CITY OF PORTLAND

Job ID: 2011-07-1749-SF

has permission to build a new Single Family Residence.

From: "Jonathan Rioux" <JRIOUX@portlandmaine.gov>
Date: August 22, 2011 1:46:39 PM EDT
To: <jonathan@redfernproperties.com>
Subject: RE: 23 Bay Street

**1 ROOF FRAMING PLAN**  
 1/4" = 1'-0"

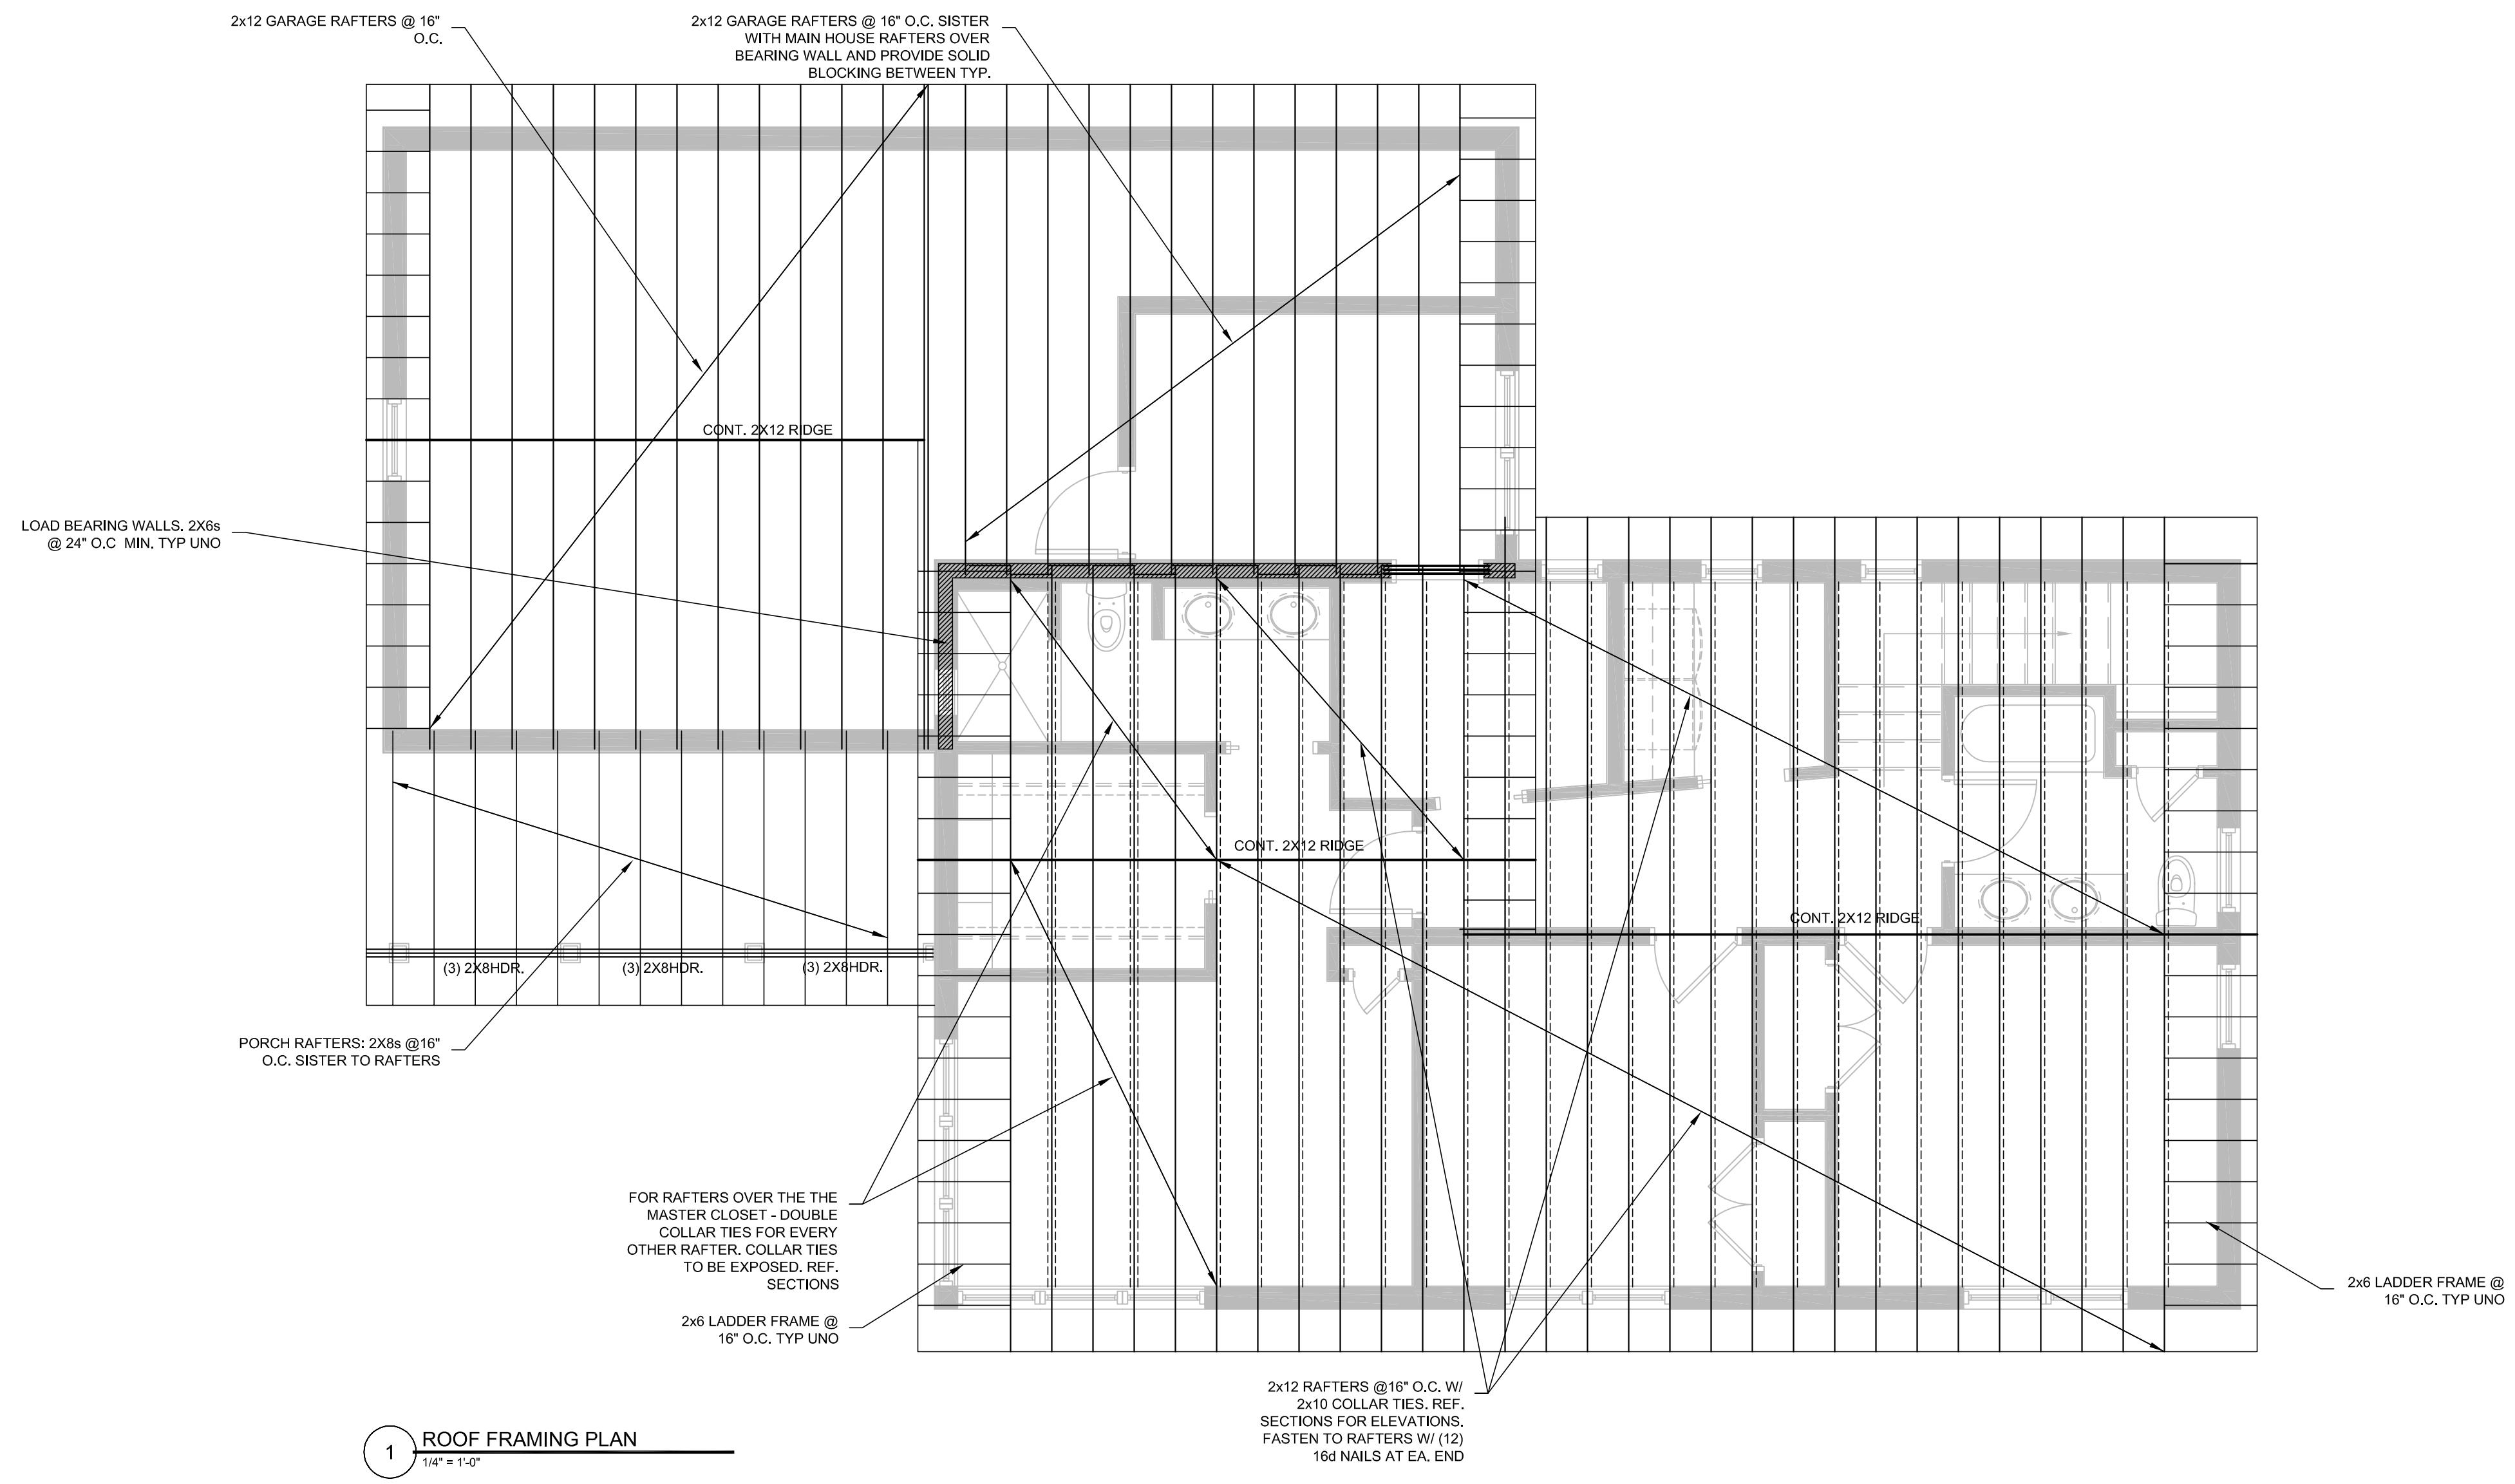
What is the roof pitch, & Connections (Section R802.3 & R802.3.1)

The Roof is a 12:12 pitch. The rafters are connected to the top plate w/ Simpson hurricane clips. The collar ties are fastened with a minimum of (6) 16d nails at each end.
